From: Chris Moore [REDACTED]
Sent: 25 April 2022 13:27
To: Nicola Moore
Subject: RE: Request for further information BR/77/22/PL - 42 Sudley Road, Bognor Regis.
Attachments: Site Plan 2.pdf

From: Chris Moore <[redacted]>
Sent: 08 April 2022 16:58
To: Nicola Moore <[redacted]>
Cc: David Poole <[redacted]>
Subject: Request for further information BR/77/22/PL - 42 Sudley Road, Bognor Regis.

PROPOSED ROOF PLAN

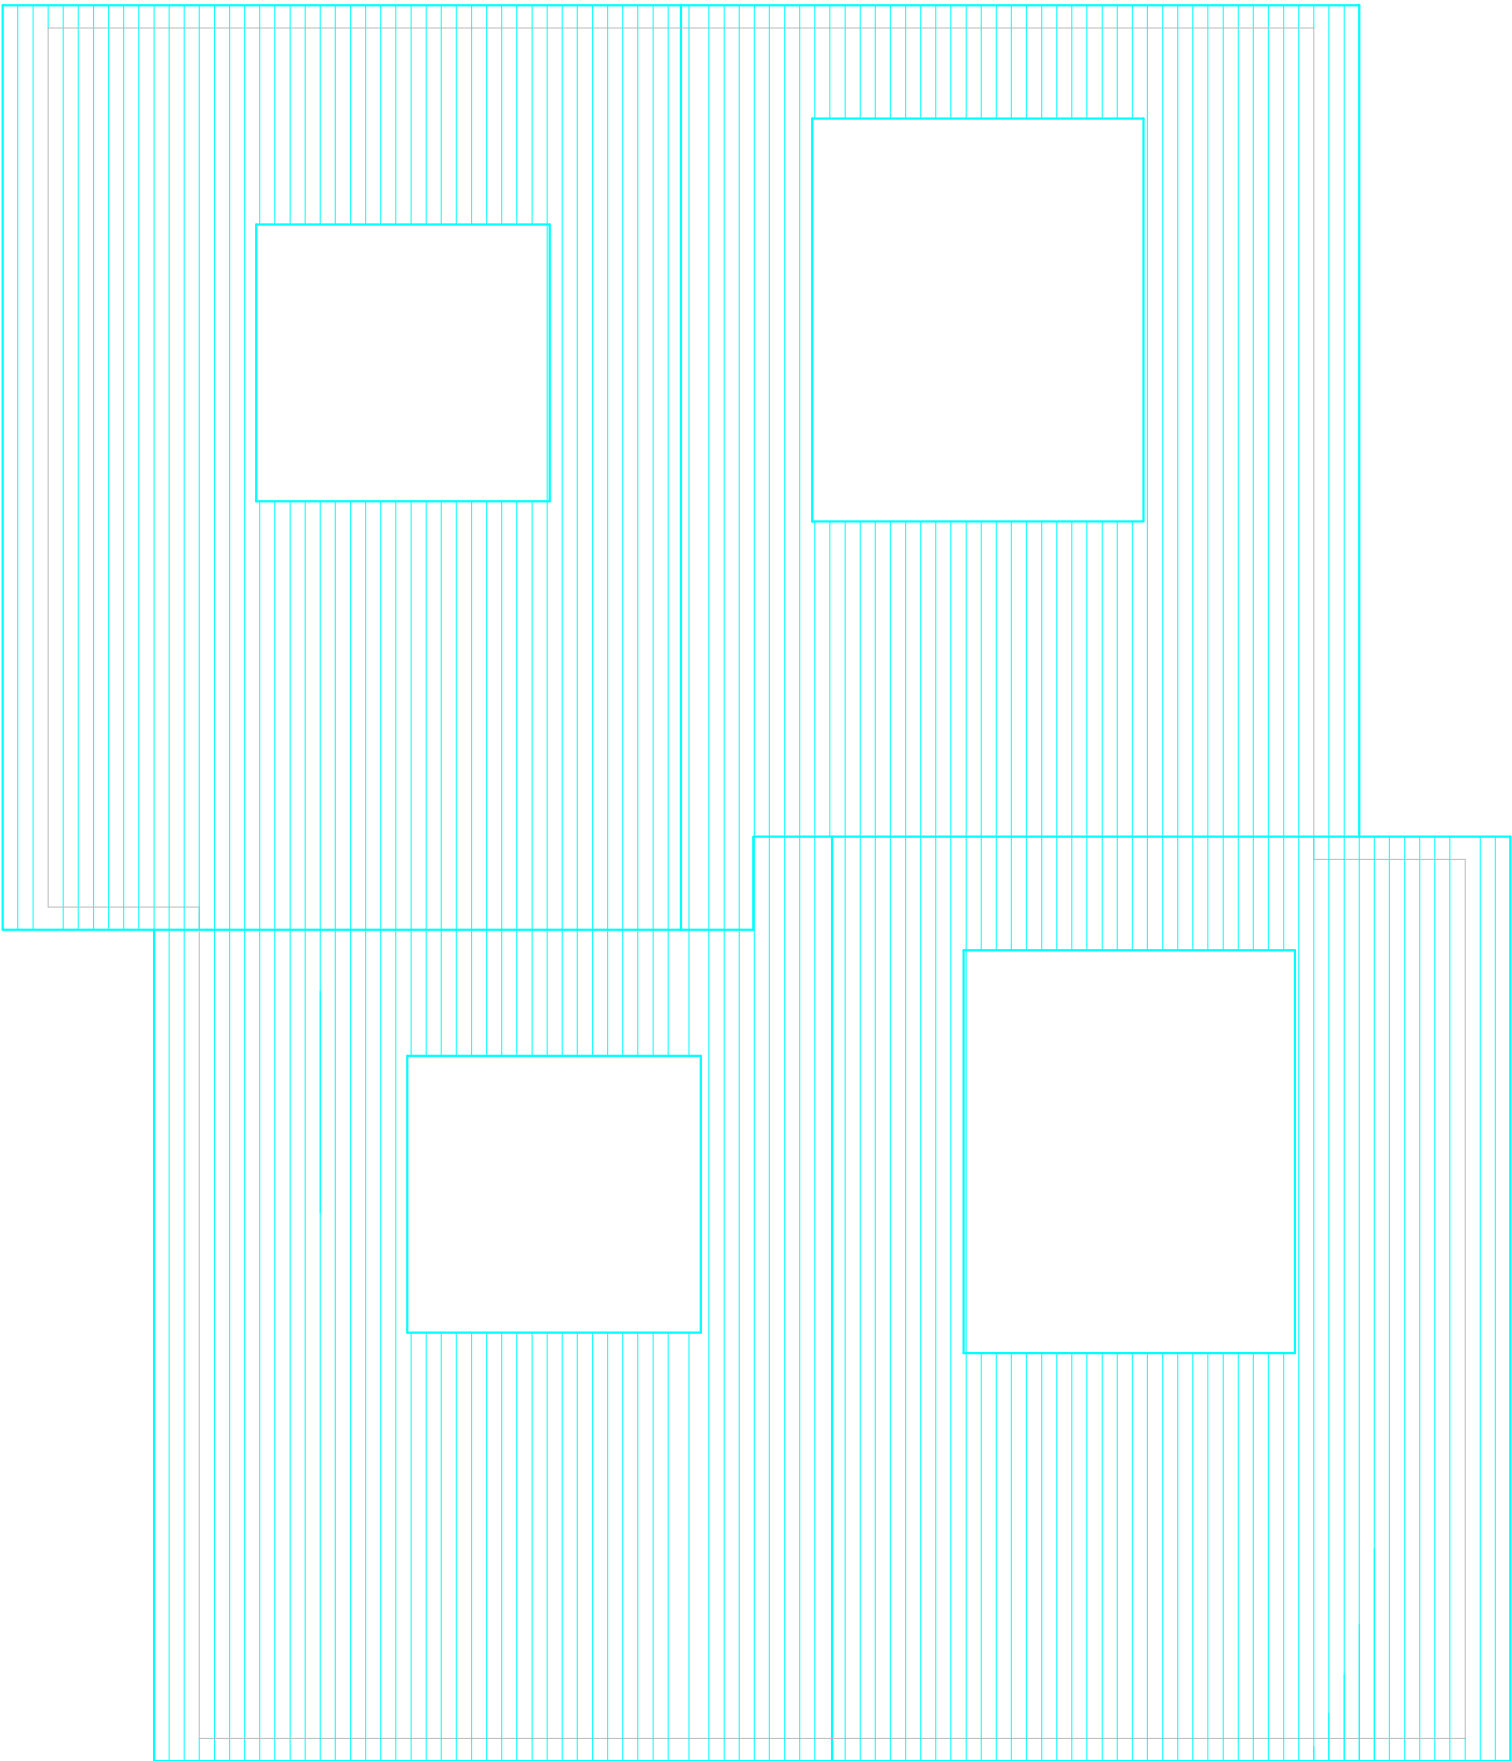
I cannot see the proposed roof plan as requested on 8th April, please forward accordingly.

I also attach a copy of the roof plan too.

SITE PLAN - 1/500

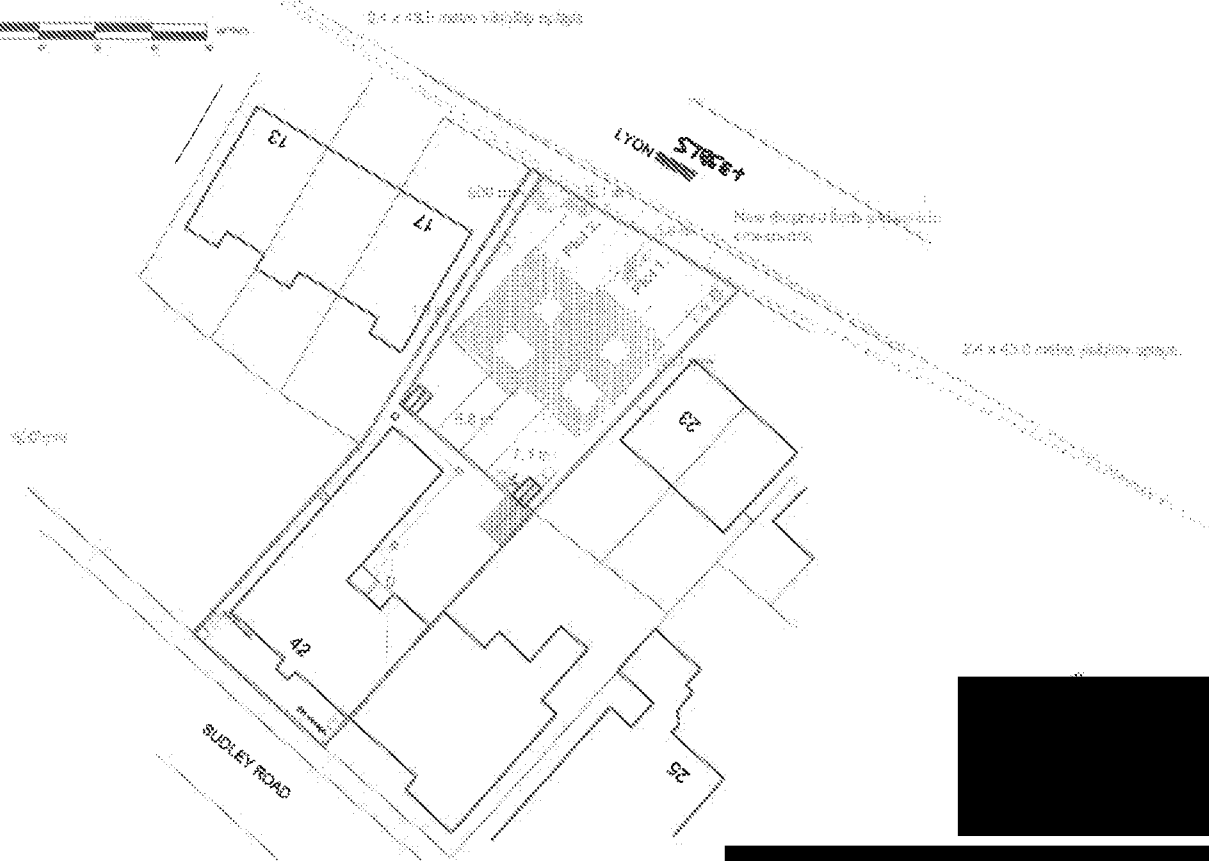
1. Location Plan – showing visibility splays. The red edge as drawn covers the land owned by the applicant which is part of this site. The public pathway is not under their ownership (WSCC Highways) are you sure this should be red edged? I have checked this with Nicola Spencer, the red edge should include the new access and notice served on relevant parties.
2. Amended elevations are attached showing the correct window size. These are now okay.
3. Site section attached. Uploaded and okay.
4. Visibility splays are shown on the site/location plan. Uploaded and okay.
5. Pagham Harbour Management Contribution Legal Agreement and Fee – I will get the applicants to organise a signed unilateral undertaking together with the appropriate legal checking fee. I will await receipt of the signed agreement and legal checking fee.

I attach a copy of the revised site/location plan with the red edge to include the highway pavement for the new access. I have served notice on WSCC and attach a copy of the Certificate B form.
